**re:** **Geotechnical Response to City Comments**  
**Proposed Commercial Development**  
480 & 486 Citigate Drive – Ottawa, Ontario

**file:** PG6514-MEMO.02

## **Geotechnical Response to City Comments**

DRAWING PG6514-2 – PERMISSIBLE GRADE RAISE PLAN

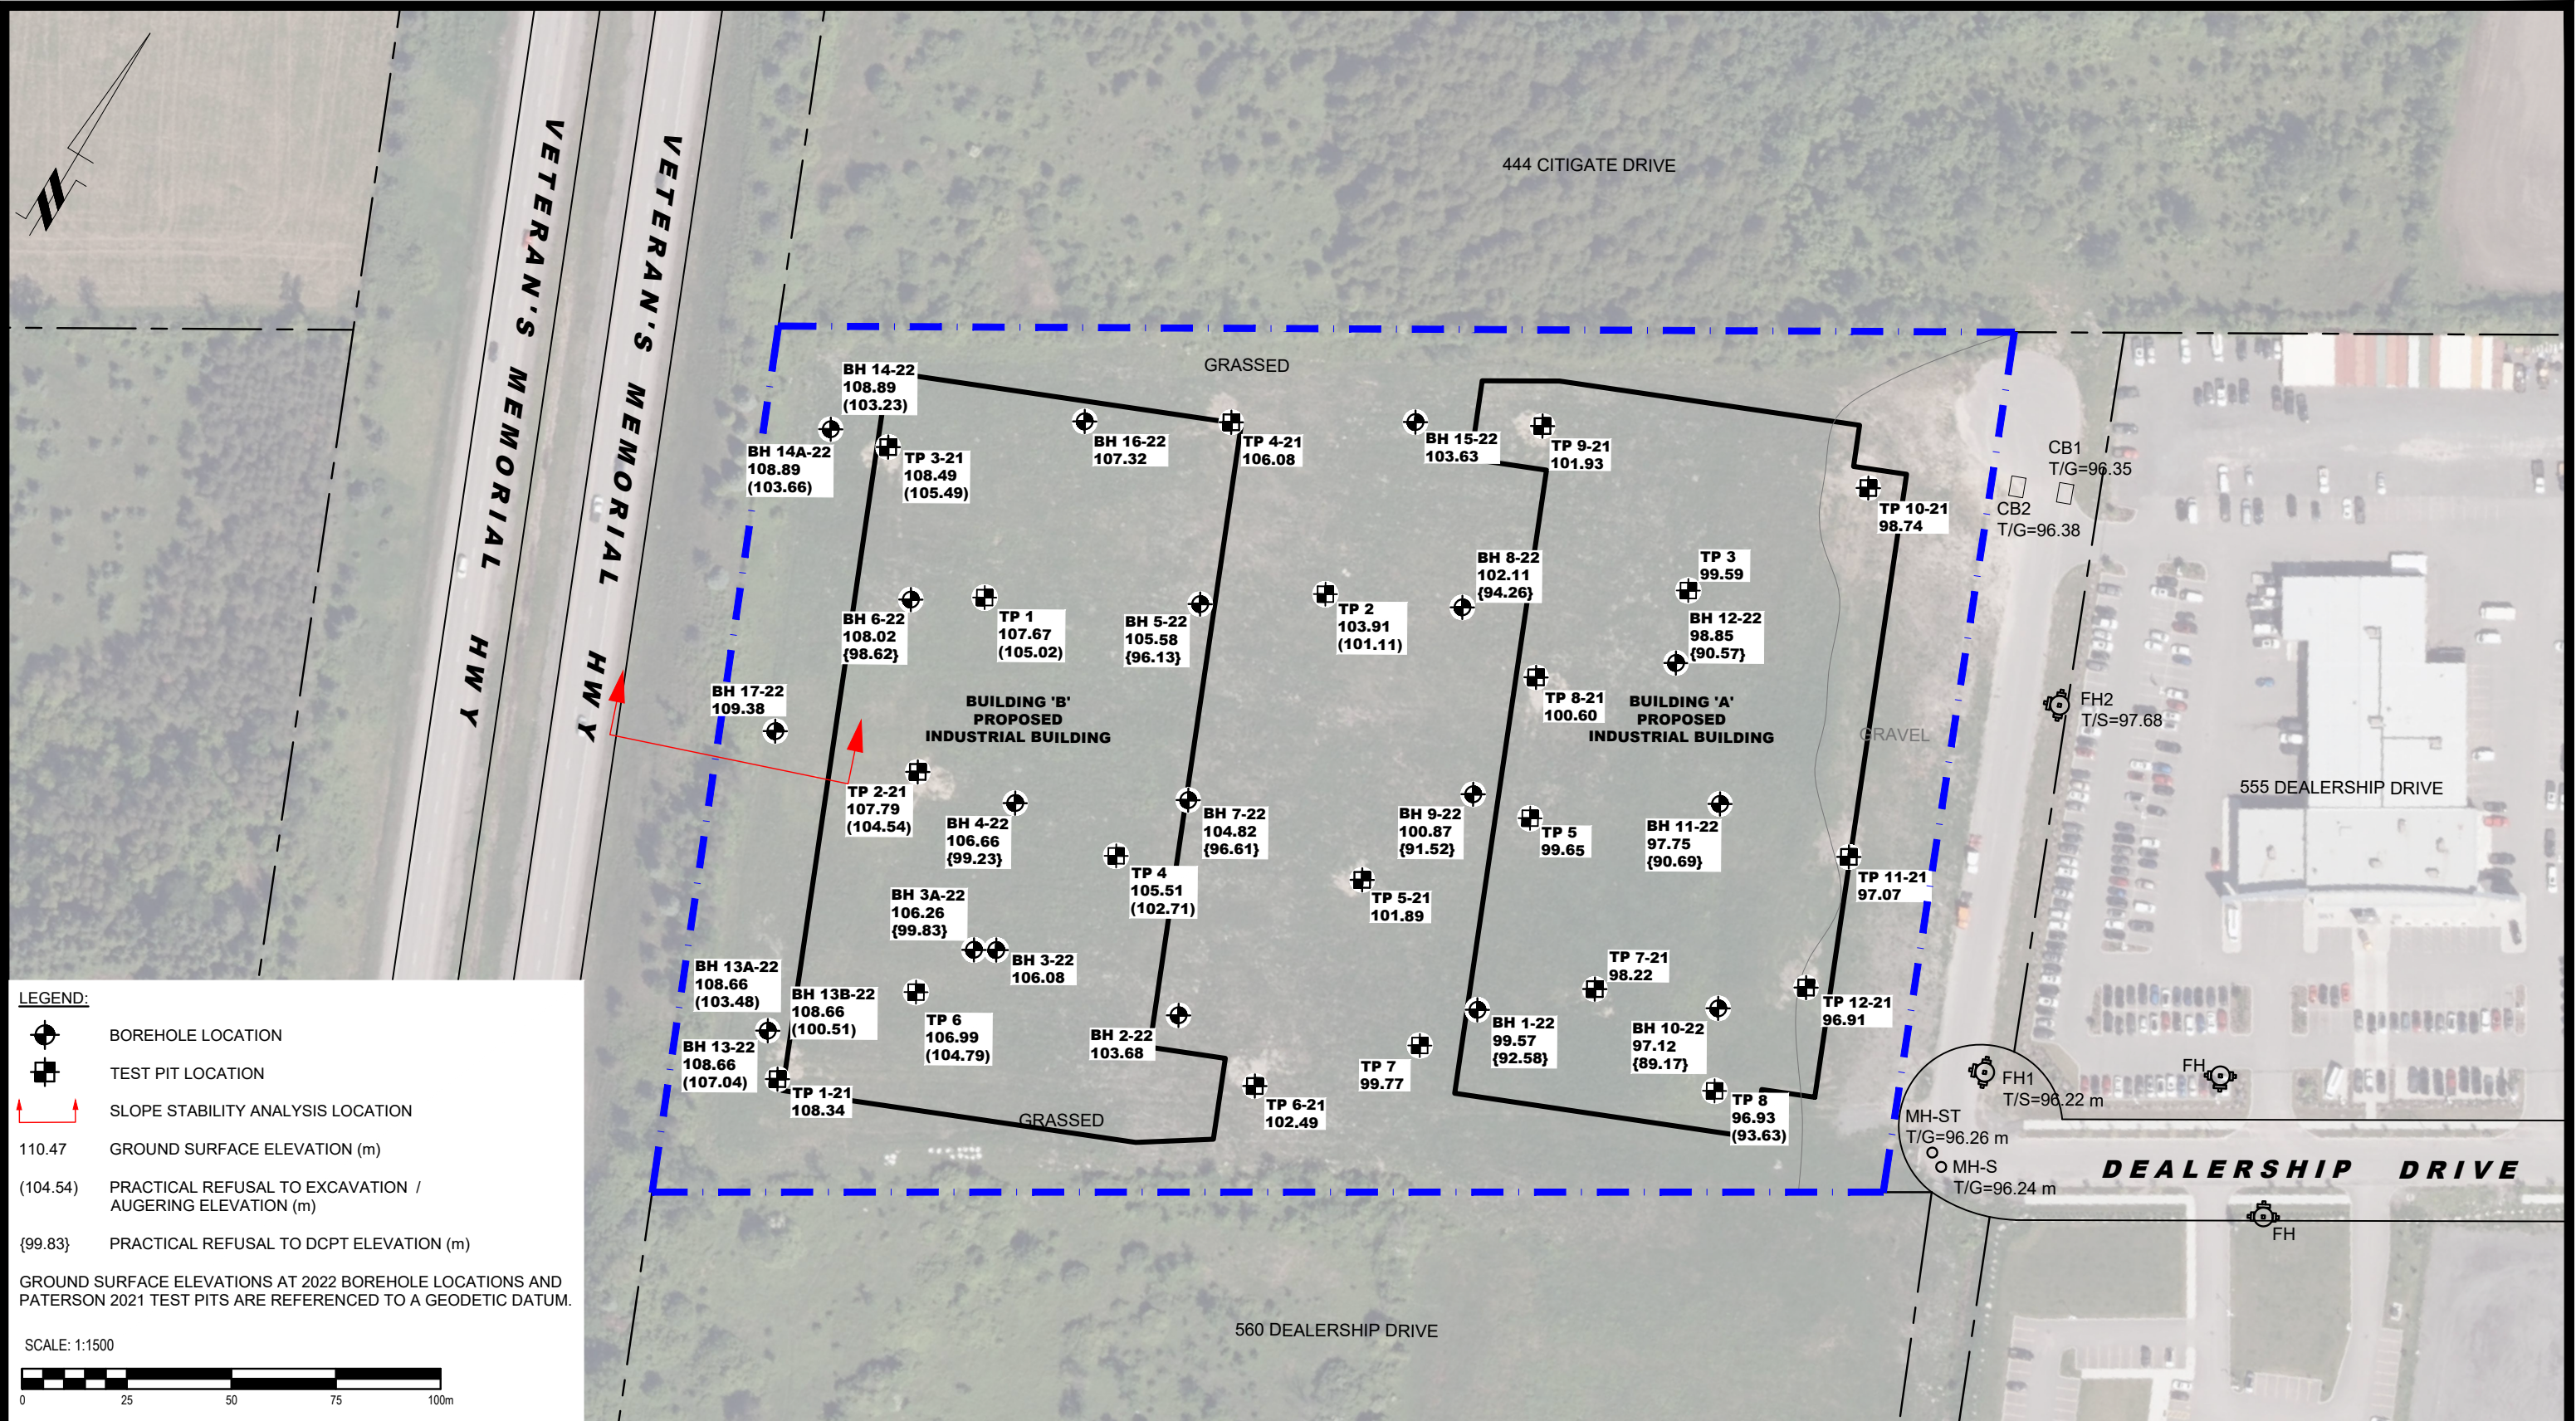
**Comment B2:** *Section 5.1 – Geotechnical Assessment: Provide a schematic and identify where the grade raise restriction is applicable.*

**Response:** Paterson prepared a permissible grade raise (PGR) plan for the subject site to identify the areas where a PGR restriction will be applicable. Reference should be made to Drawing PG6514-2 – Permissible Grade Raise Plan attached to Paterson Group Report PG6514-1 Revision 2 dated October 10, 2023, for the grade raise restriction recommendations plan.

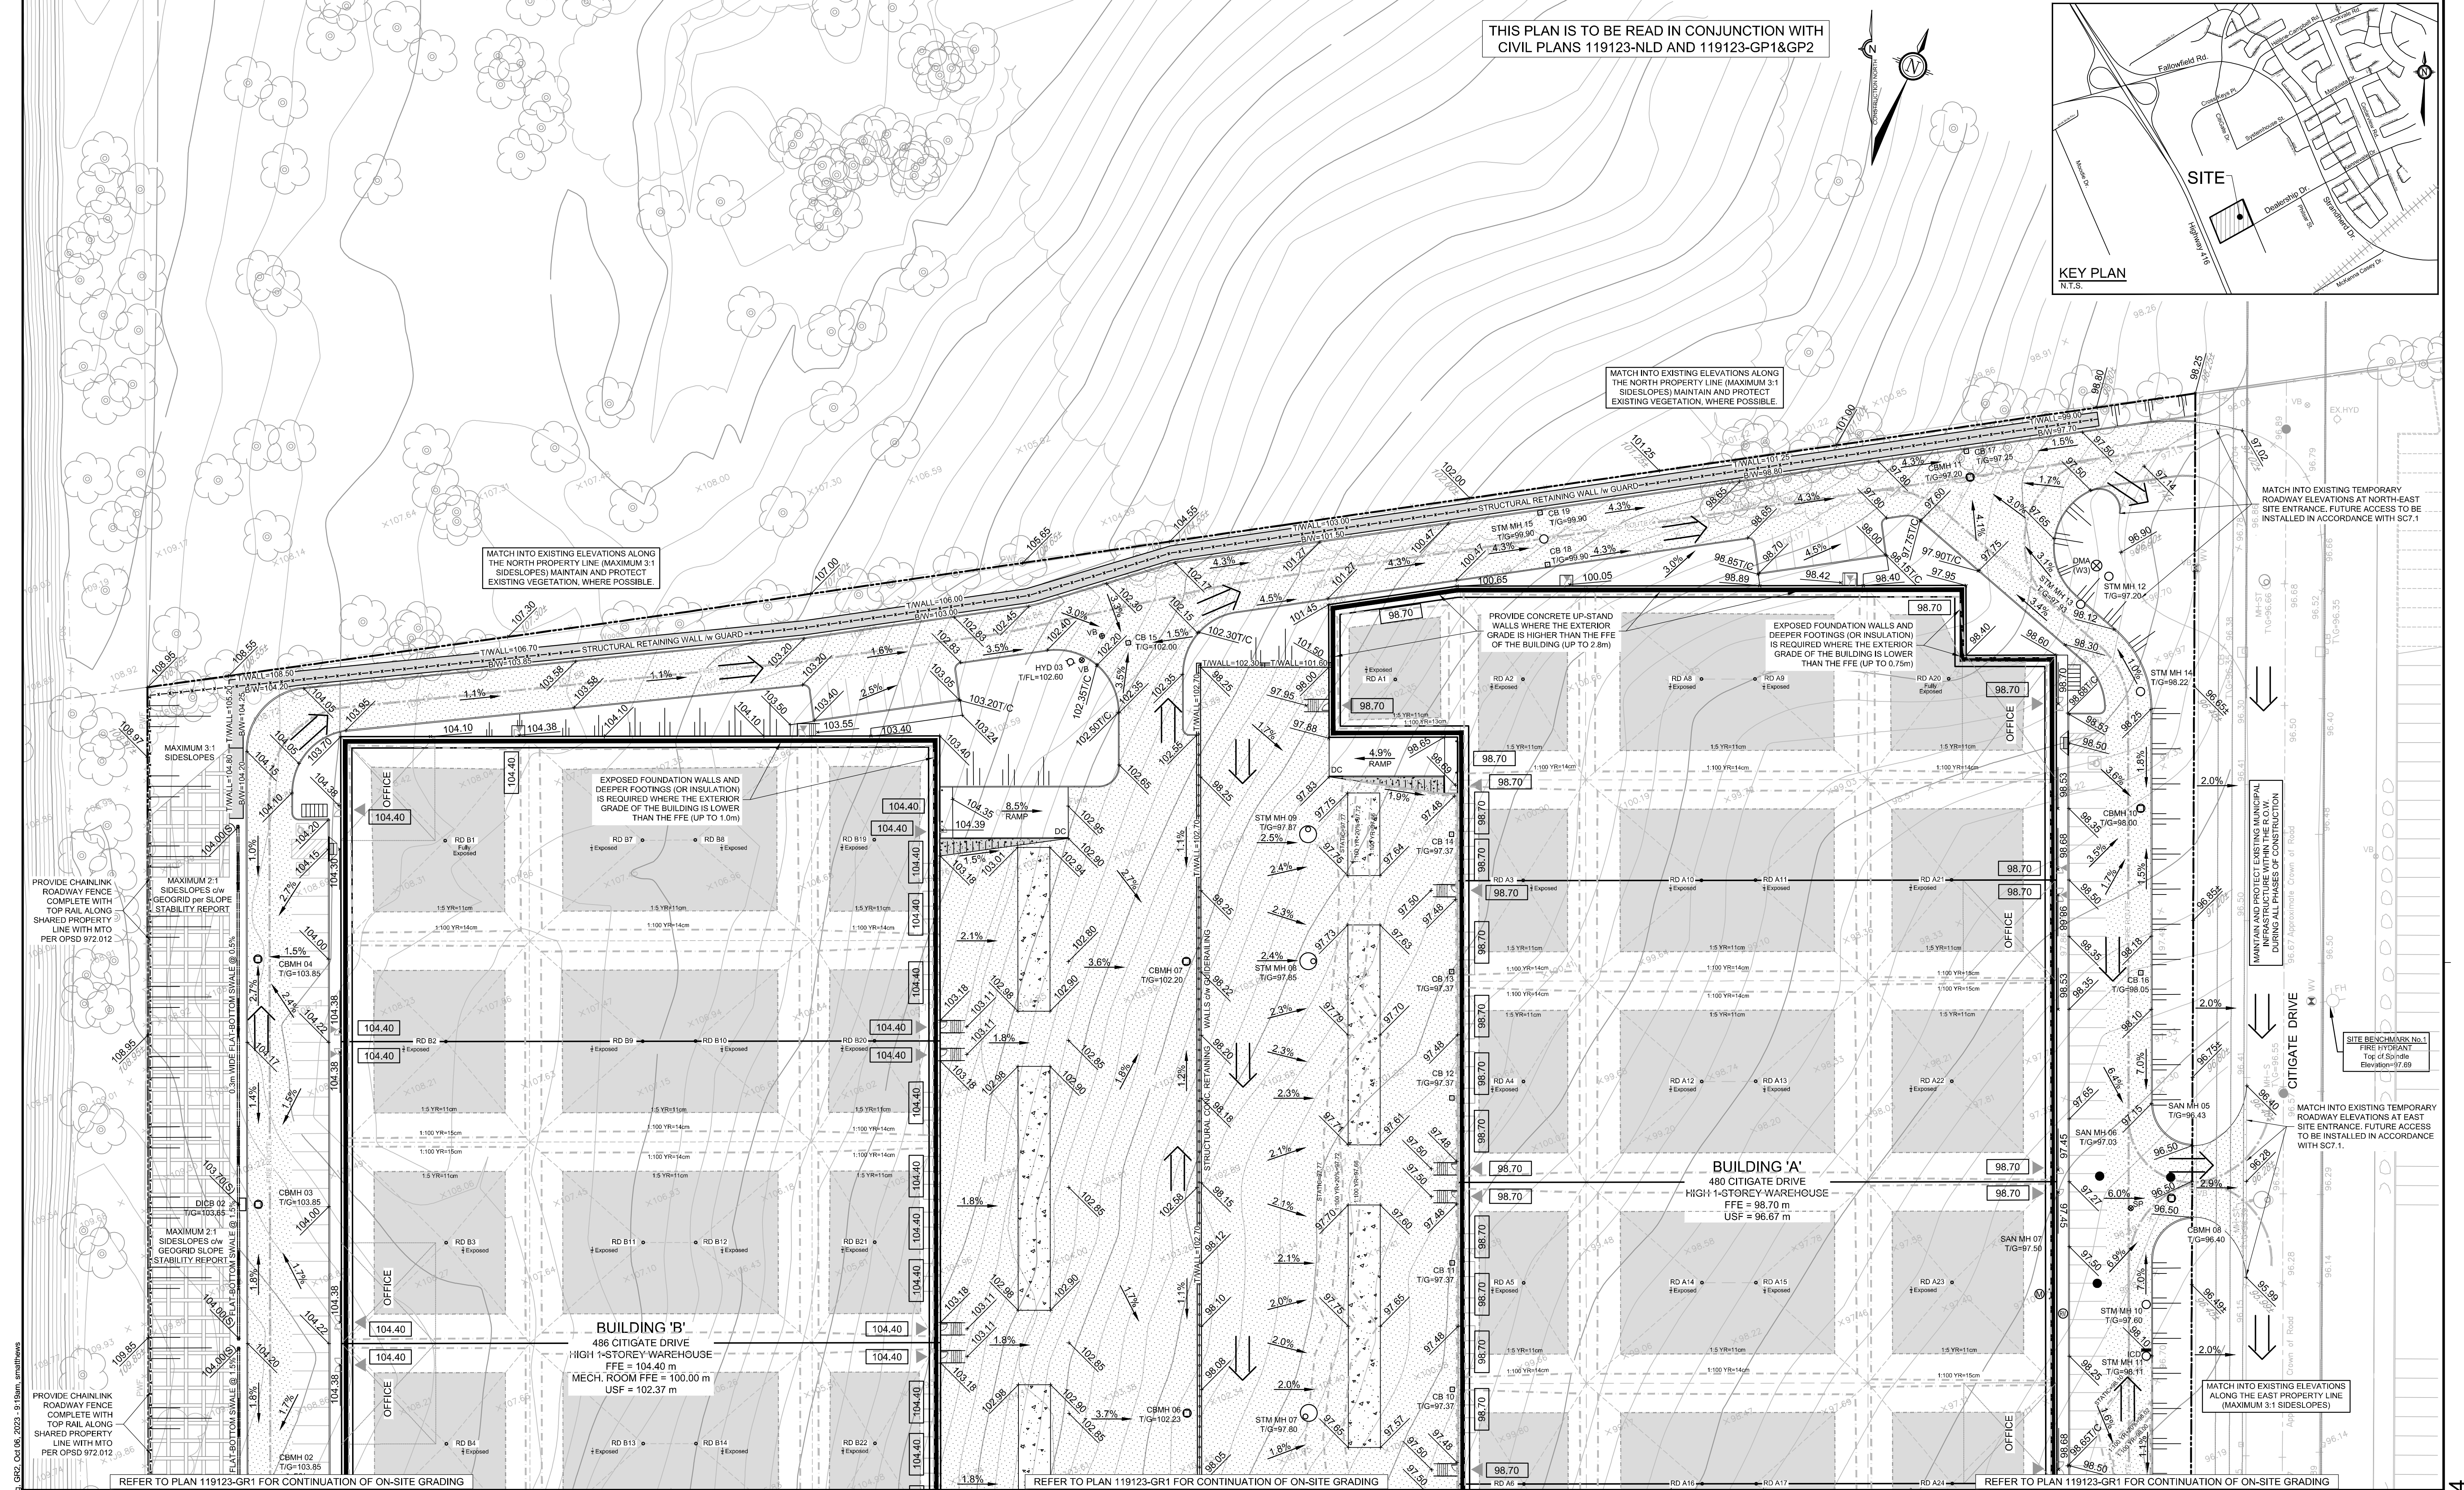
**Comment A11:** *Provide geotechnical sign-off on the latest revision of the grading plan.*

**Comment B3:** *Provide geotechnical sign-off on the latest revision of the Grading Plan.*

**Response:** Paterson reviewed the latest grading plans for the proposed commercial development at the subject site, from a geotechnical perspective. Based on our review, the proposed grading is generally acceptable from a geotechnical perspective. Details of our review and geotechnical recommendations can be found in Paterson Group Memorandum PG6514-MEMO.03 dated October 10, 2023.

**Response:** Refer to our response to comment A11 above.
